Ribble Valley Borough Council

App no: 3.2026.0346

Address: Ground floor Unit 6 Abbey Works King Street Whalley

Proposal: Regularisation of change of use of ground floor to indoor sport and recreation (Class E (d))

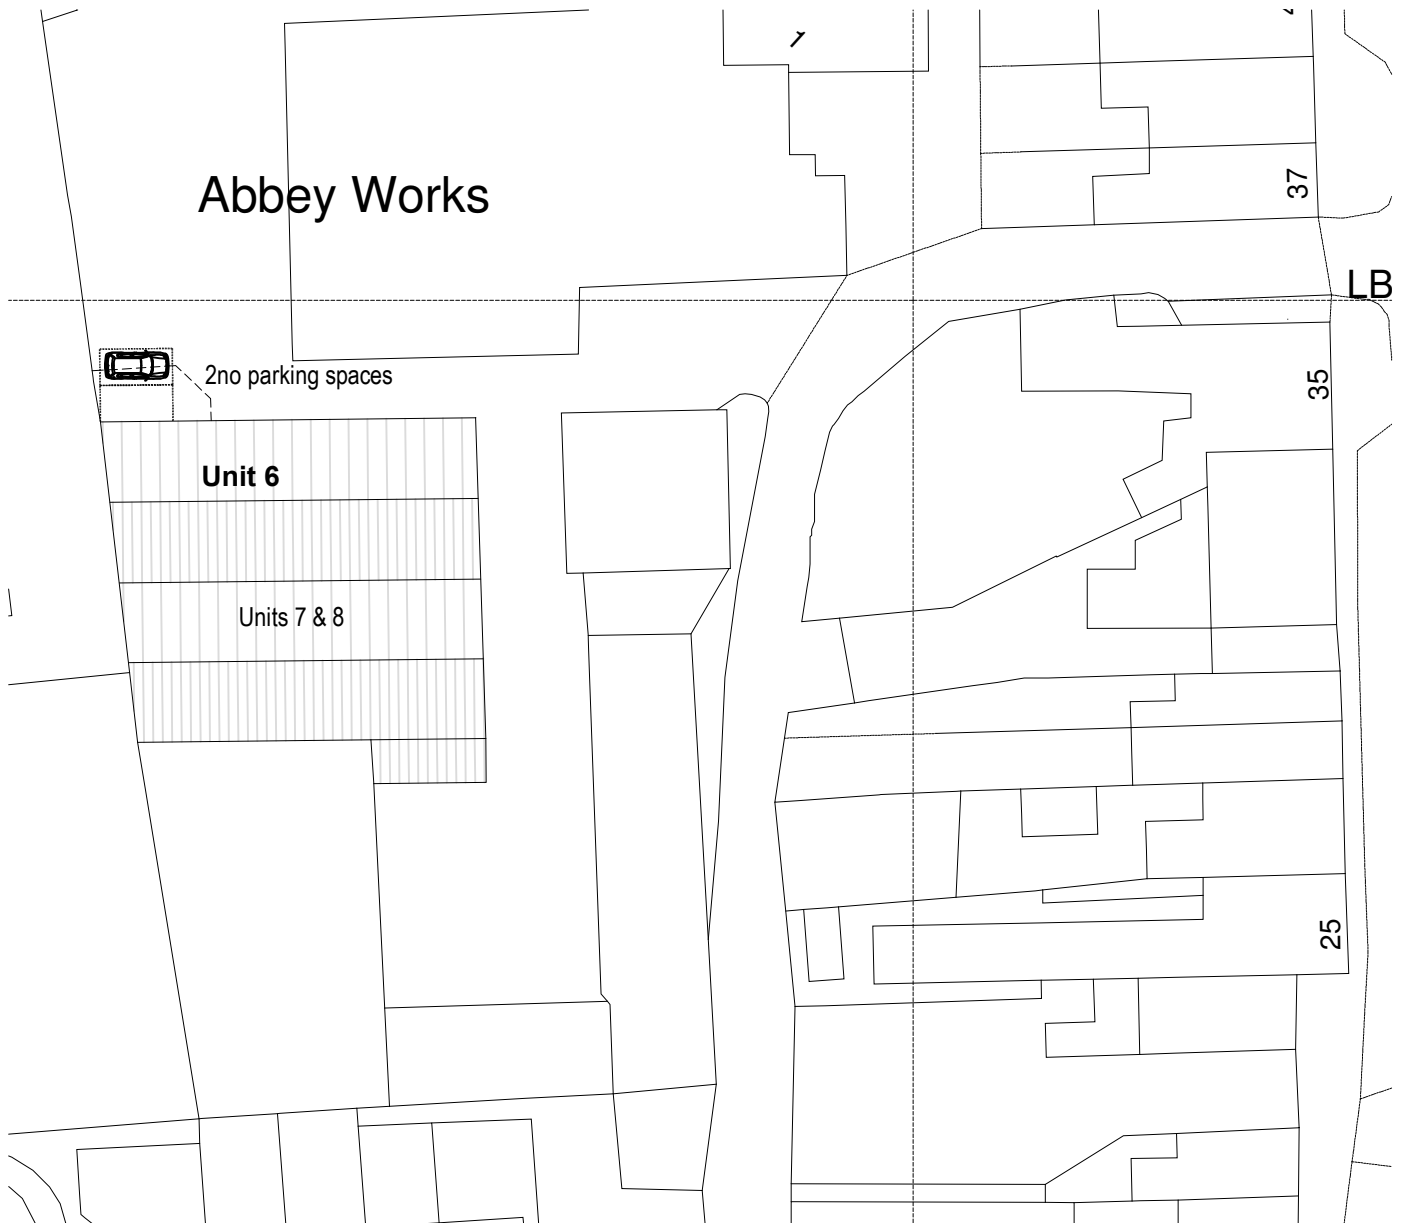
There is no separate footway into the commercial area and no street lighting and there is a concern that attendees parking off site will be in conflict with commercial vehicles. Unaccompanied children would be a particular concern.

There are 2 car parking spaces proposed to be provided.

The proposed use will result in some conflict between pedestrians and commercial vehicles within the site which the applicant has not demonstrated how this will be managed to minimise this.
